APPLICATION CONSULTATION RESPONSE

Application Number:	3/2017/0357
Location:	Lower Moss Farm, Lower Ln, Longridge, PR3 2YH
Grid Ref:	361015/436658
Proposal:	Development of site for the construction of 10 no. holiday units

PROPOSED SITE PLAN	
Site: Lower Moss Farm Lower Lane Longridge	
Client: Rainford	
Date: 1.04.17	Scale: 1:500 @ A2
Project No: RAI/10 Dwg 02	Drawn: KH
Amendments:

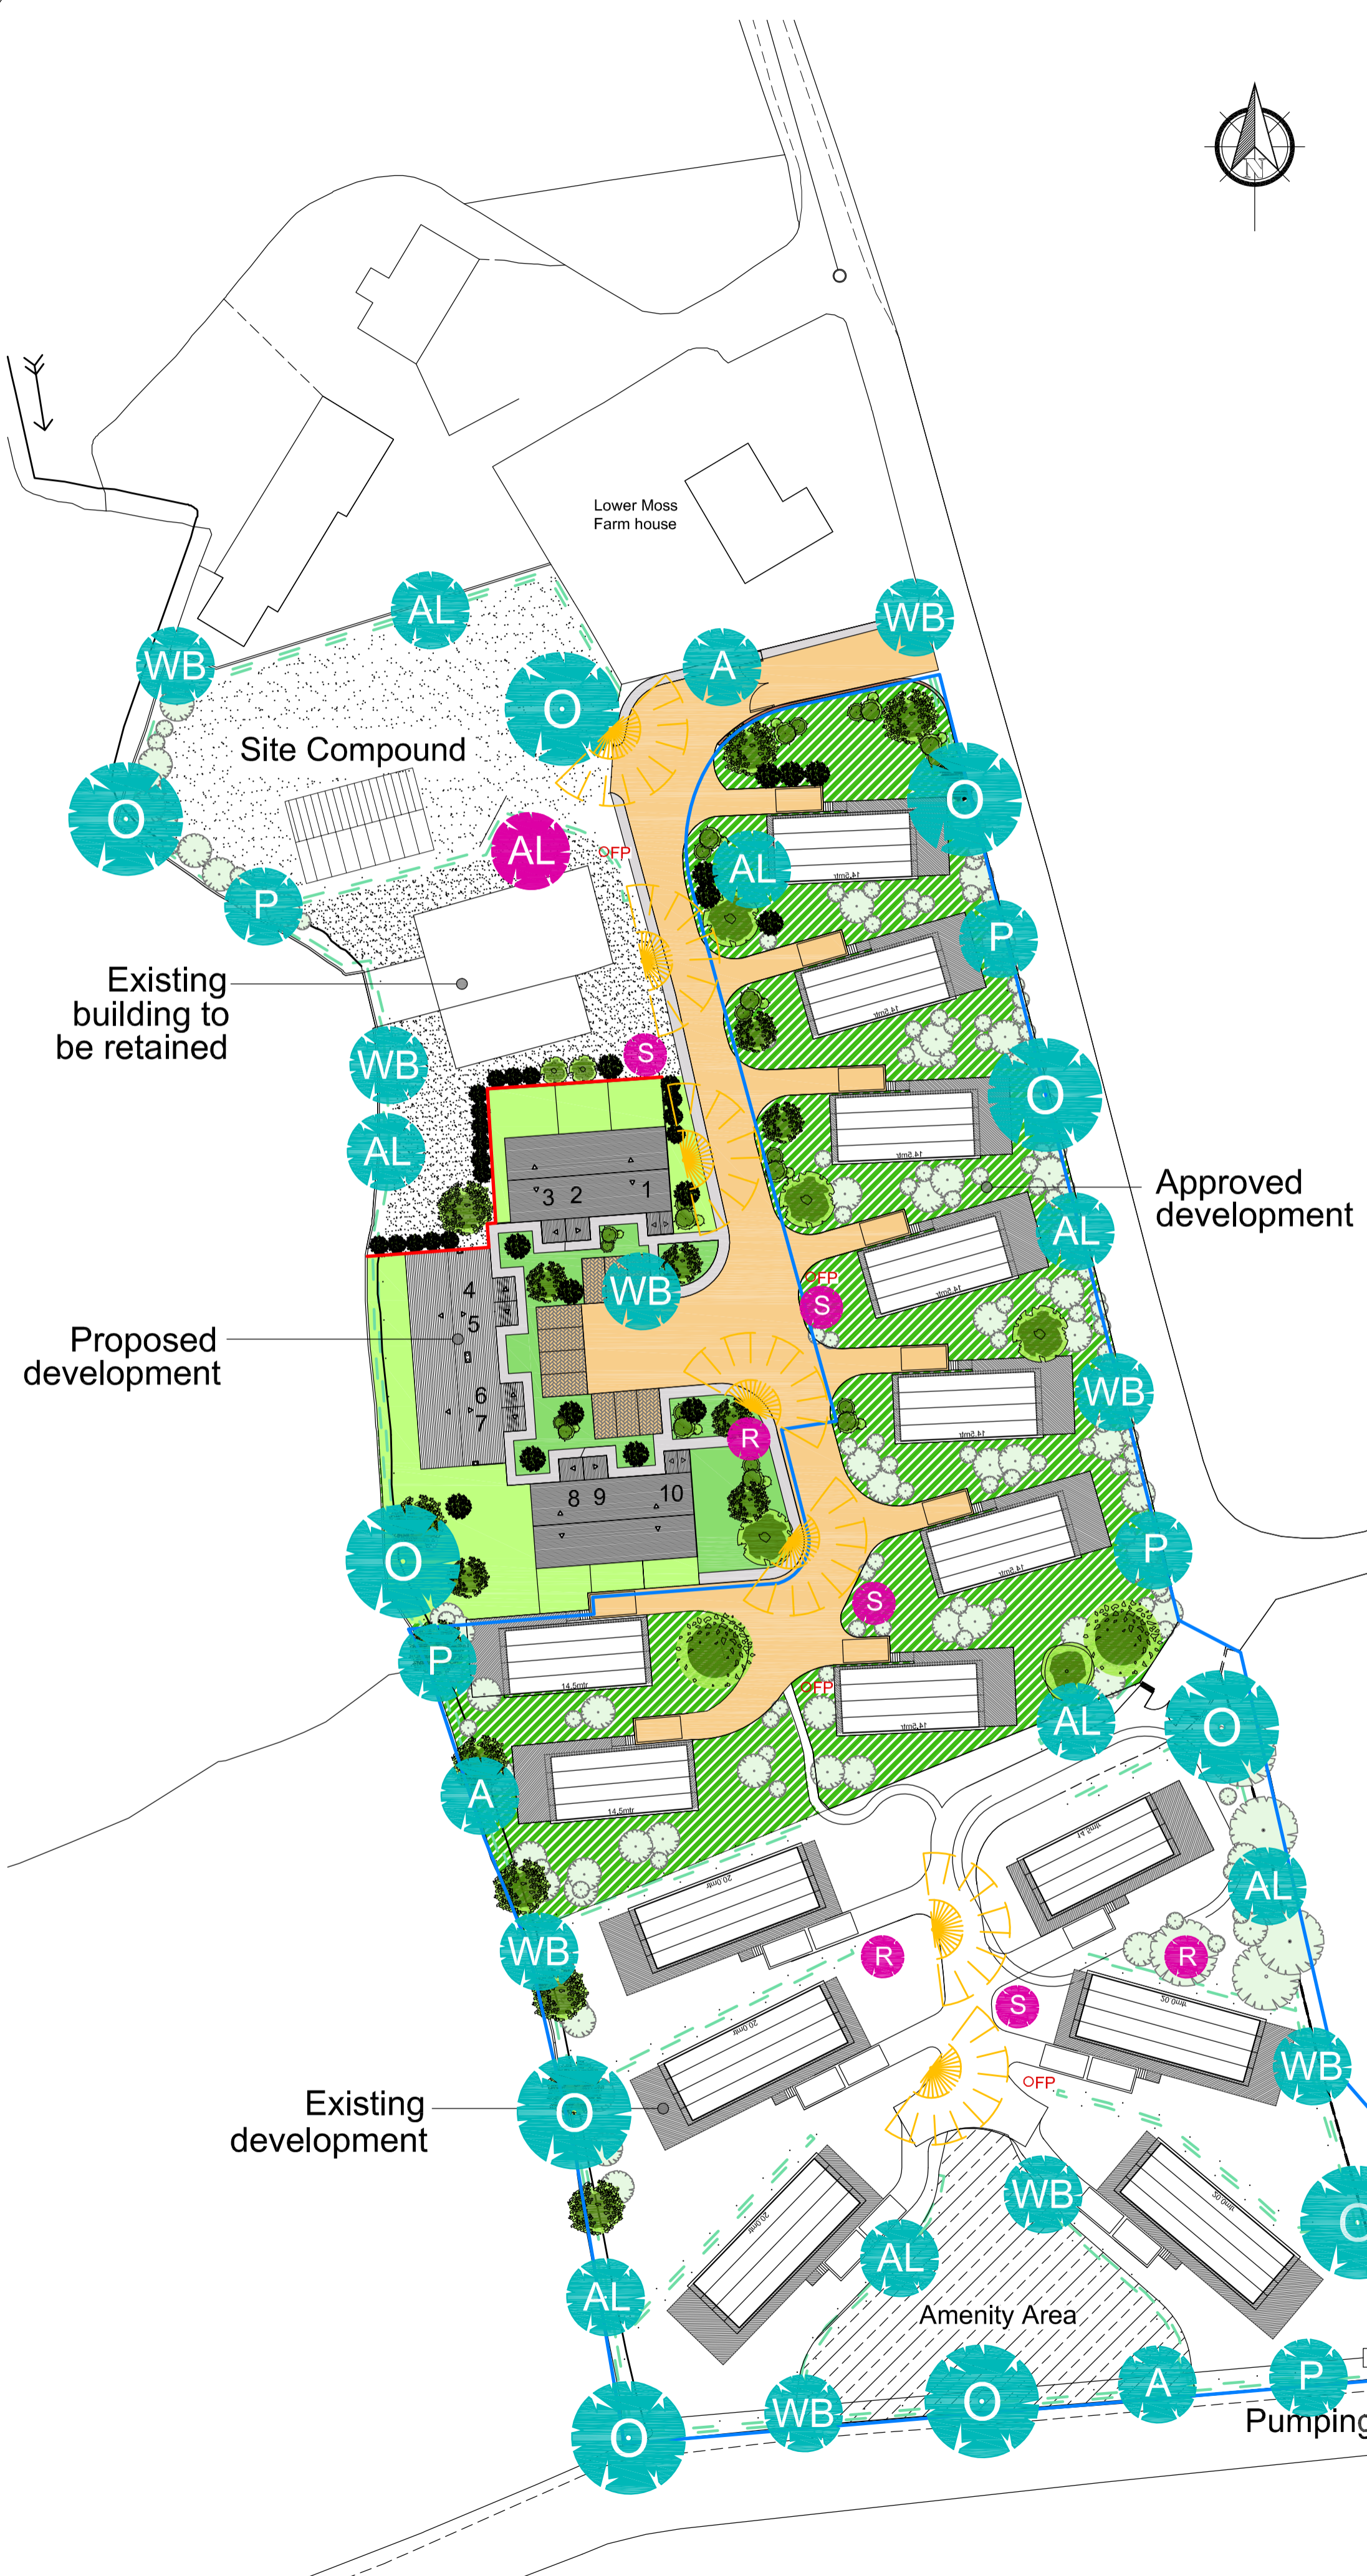
Desktop study to incorporate maps showing: <ul style="list-style-type: none">• Existing surface water flow routes, drains, sewers and watercourses• Surface water and groundwater flood risk• Geological and soil types
Proposed site plan showing: <ul style="list-style-type: none">• Exceedance routes and identification of catchment area(s)
Drainage layout plan, to include: <ul style="list-style-type: none">• Sustainable drainage system• Sewers• Drains• Watercourses• Outfall locations• Discharge rates• On-site storage requirements
Site investigation report, including the results for each sustainable drainage system (SuDS) feature of: <ul style="list-style-type: none">• Boreholes or Trial Pits• Infiltration (Permeability) Testing• Factual Ground Investigation Report (GIR)• Geotechnical Design Report (GDR)
Detailed design drawings, including: <ul style="list-style-type: none">• Details of inlets, outlets and flow controls• Long and cross section drawings of proposed drainage system(s), including design levels• Details of appropriate water quality treatments• Sustainable drainage system flow calculations (<i>PDF files showing the input and output data for flow calculations</i>) and storm simulation plan for: 1 in 1 year, 1 in 2 year, 1 in 30 year, and, 1 in 100 year + climate change

The Lead Local Flood Authority also strongly encourages that the developer should take into account designing drainage systems for exceedance working with the natural topography for the site. Should exceedance routes be used, the applicant must provide a site layout plan with these displayed, in line with Standard 9 of DEFRA's Technical Standards for SuDS.

The proposals indicate that the applicant may intend to discharge surface water into the open watercourse at the west side of the development site.

You can overcome our objection by submitting information which demonstrates how surface water will be managed on site, satisfying the principles of Paragraph 103 of the NPPF and Paragraph 80 of Section 10 of the PPG. If this cannot be achieved we
